Submission for Job: #6011 SSD 6011 - Mixed use residential development within the South West Plot
https://majorprojects.affinitylive.com/?action=view_job&id=6011

SSD 6011 - Mixed use residential development within the South West Plot

30 July 2013

## Winter Solstice (21<sup>st</sup> June)

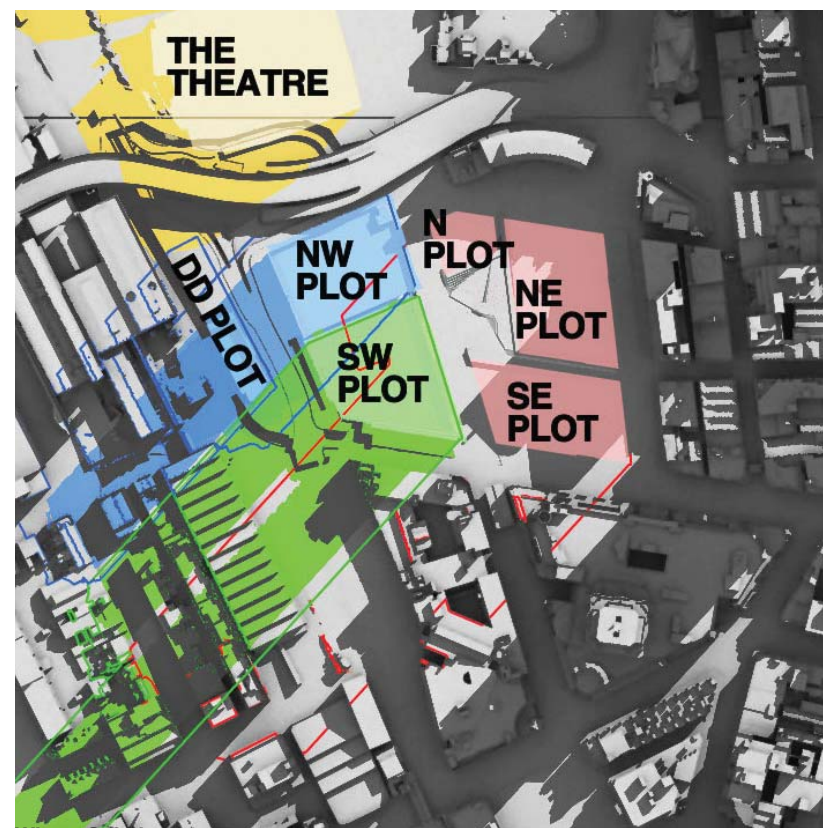
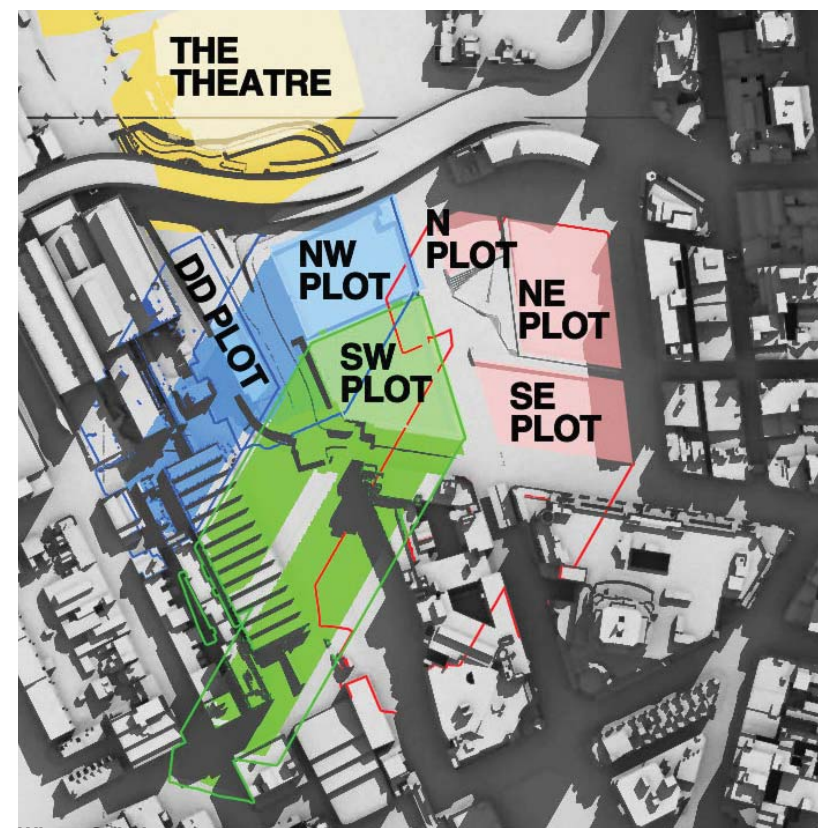
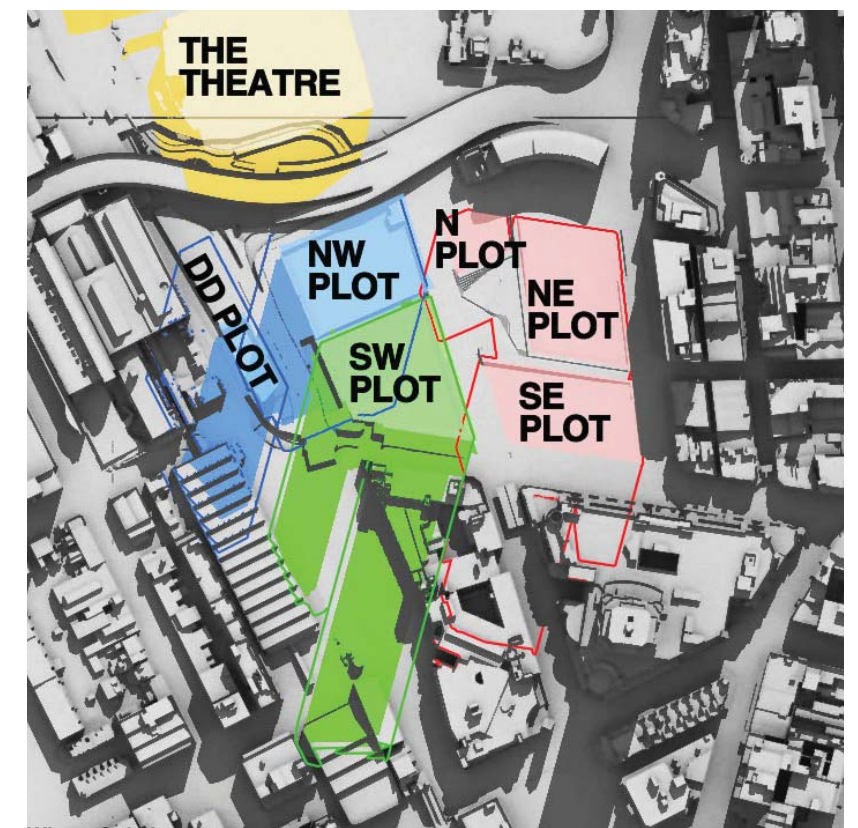
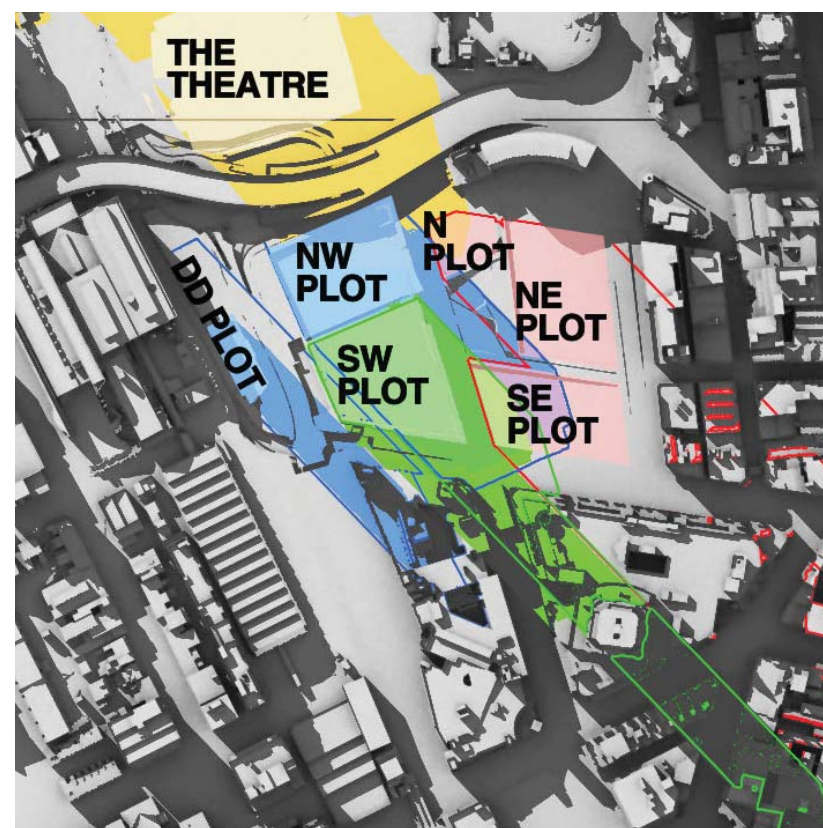
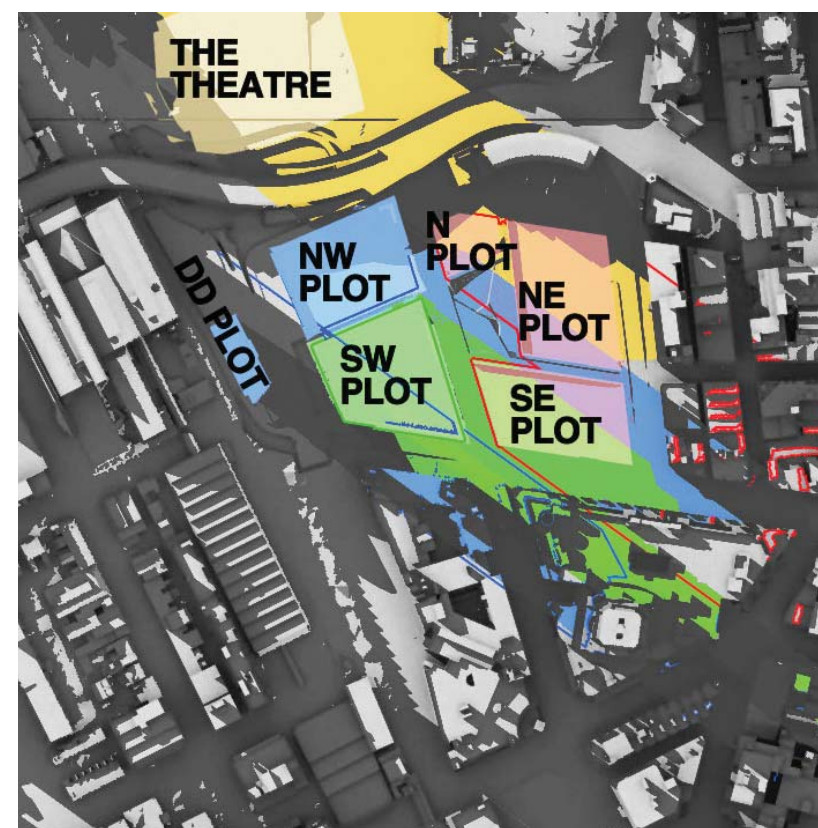
The proponent provides diagrams but fails to discuss the existing shadowing of the west façade of The Peak.

At 9am, 10am and 11am the west façade is totally in shadow due to other parts of The Peak building itself.

At 12pm there is still substantial existing shadowing on the west façade caused by the irregular shape of the west facade.

At 1pm the existing shadowing has been substantially removed, but not totally removed.

It can be concluded that some single aspect apartments on the west façade and some south-west dual aspect corner apartments currently receive less than 2 hours direct sunlight to habitable rooms and 50% of the private open space between 9am and 3pm on 21 June.

By 2pm the existing shadowing has been totally removed, but that is too late to achieve two hours of direct sunlight before 3pm.

At 9am, 10am and 11am the west façade is totally in shadow due to other parts of The Peak building itself.

At 12pm there is still substantial existing shadowing on the west façade caused by the irregular shape of the west facade.

At 1pm the existing shadowing has been substantially, although not entirely, removed. However, overshadowing of lower levels of the west façade by the concept proposal parameter plan shadows for the N,NE and SE plots has already started.

By 2pm the existing shadowing has been totally removed. However, overshadowing of the west façade by the SSDA4 and SSDA5 buildings has appeared and risen further up the west façade than the concept proposal parameter plan shadows for the N,NE and SE plots, which is still present.

At 3pm, the proponent states correctly that 45-45% of the western façade is overshadowed by the SSDA4 and SSDA5 buildings.

It can be concluded that, as a result of combination of the proposed development with existing shadowing of the west façade, some single aspect apartments on the west façade and the south-west dual aspect corner apartments which currently receive less than 2 hours direct sunlight to habitable rooms and 50% of the private open space between 9am and 3pm on 21 June will suffer additional overshadowing. It is beyond our skills to count the number of such apartments. We note that the proponent has made no attempt to do so.

Rather than counting the number of units which will not meet the DCP guidelines, the proponent attempts to trade-off direct sunlight at 4pm for lack of direct sunlight during the period 9am to 3pm. There is no provision in the DCP guidelines for such a trade-off.
